**Subject: Major Projects – New Request for Advice - Residential Flat Building at 40-76 William Street, Leichhardt (SSD-119545240) (Inner West)**

MCEF has reviewed the *Residential Flat Building at 40-76 William Street SSD-119545240 - Flood Impact and Risk Assessment Report* prepared by Beveridge Williams, March 2023. Detailed assessment is included in the table at Attachment 1.

## ATTACHMENT 1

Figure 4: Proposed 1% AEP Depth and Extents (Source - Mott MacDonald)

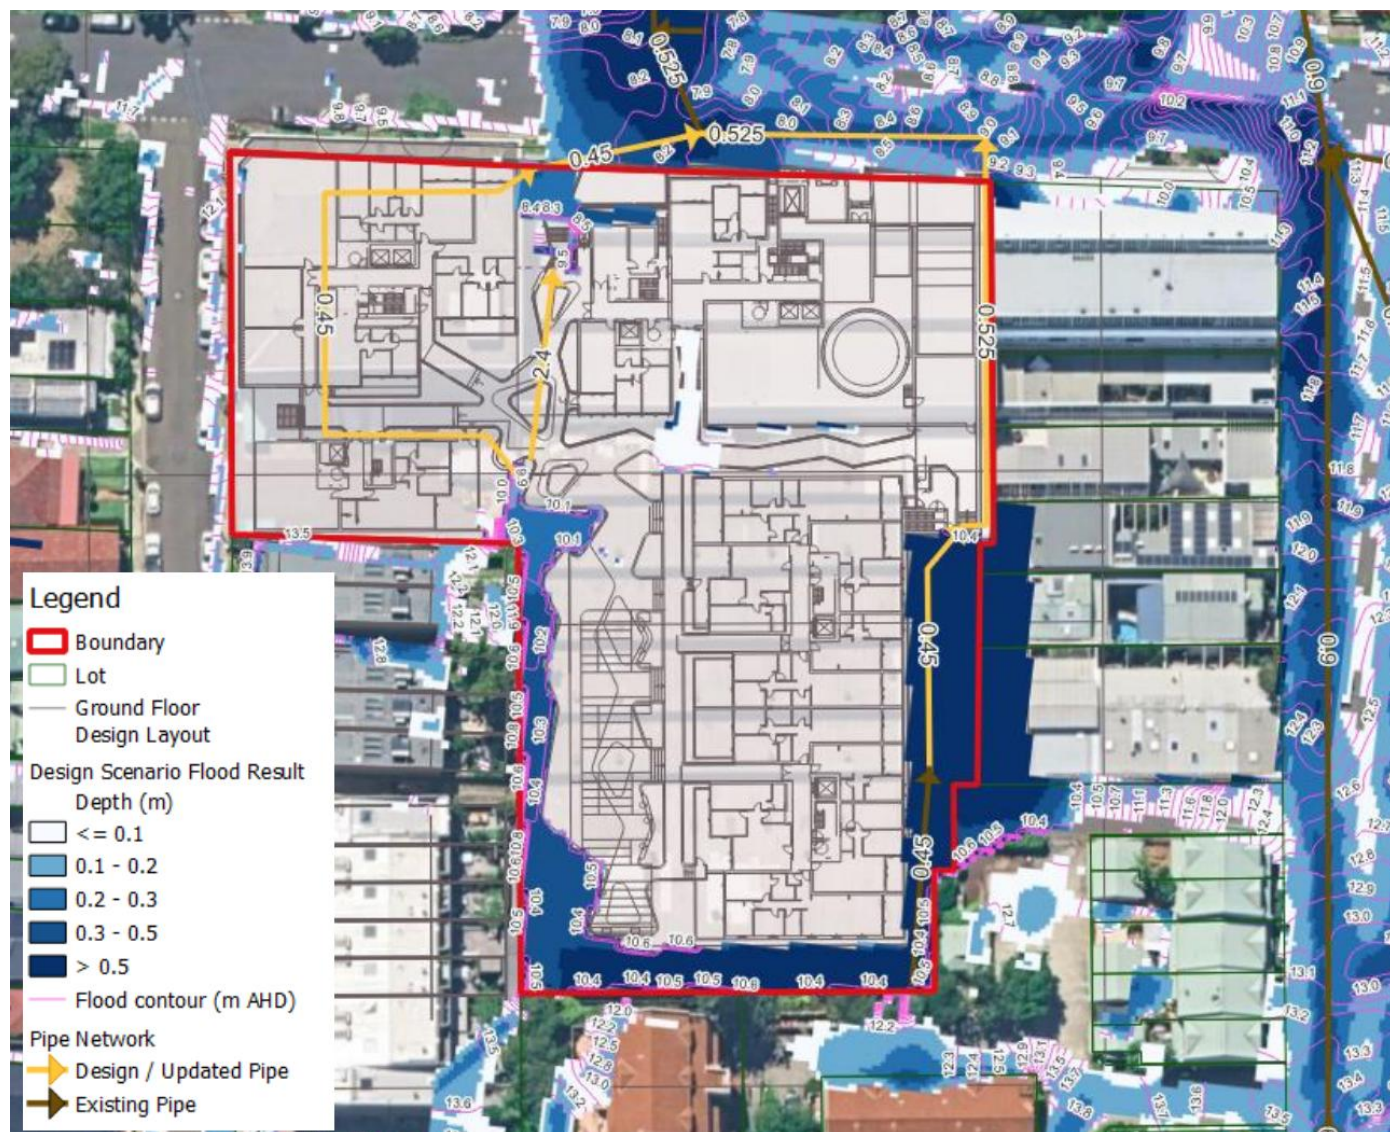
| <b>Assessment of the Full Range of Flood Risk</b> | <p>Insufficient flood information has been provided to adequately assess the full range of flood risk affecting the site and future occupants.</p> <p>The FIRA only provides flood mapping and hazard information for the 1% AEP and PMF events. The assessment demonstrates that the site is subject to significant flooding during the 1% AEP event, including H5–H6 flood hazard conditions affecting William Street. However, no information has been provided for more frequent flood events.</p> <p>As a result, the assessment does not adequately identify:</p> <ul style="list-style-type: none"> <li>▪ the frequency at which site access is affected by flooding</li> <li>▪ the frequency of hazardous flooding along William Street</li> <li>▪ the frequency of resident isolation</li> <li>▪ the frequency of emergency access and evacuation constraints</li> <li>▪ the full range of flood risk likely to be experienced by future residents.</li> </ul> <p>Flood Risk Management Guideline LU01 and EM01 require consideration of the full range of flooding and associated emergency management constraints, including isolation, evacuation and access issues across multiple flood events. The current assessment does not adequately address these requirements.</p> <p><b>Recommendation</b><br/>Provide flood mapping, hazard mapping and emergency management assessment for the full range of flood events, including the 10%, 5%, 1%, 0.5% (or 0.2%) AEP and PMF events.</p> |
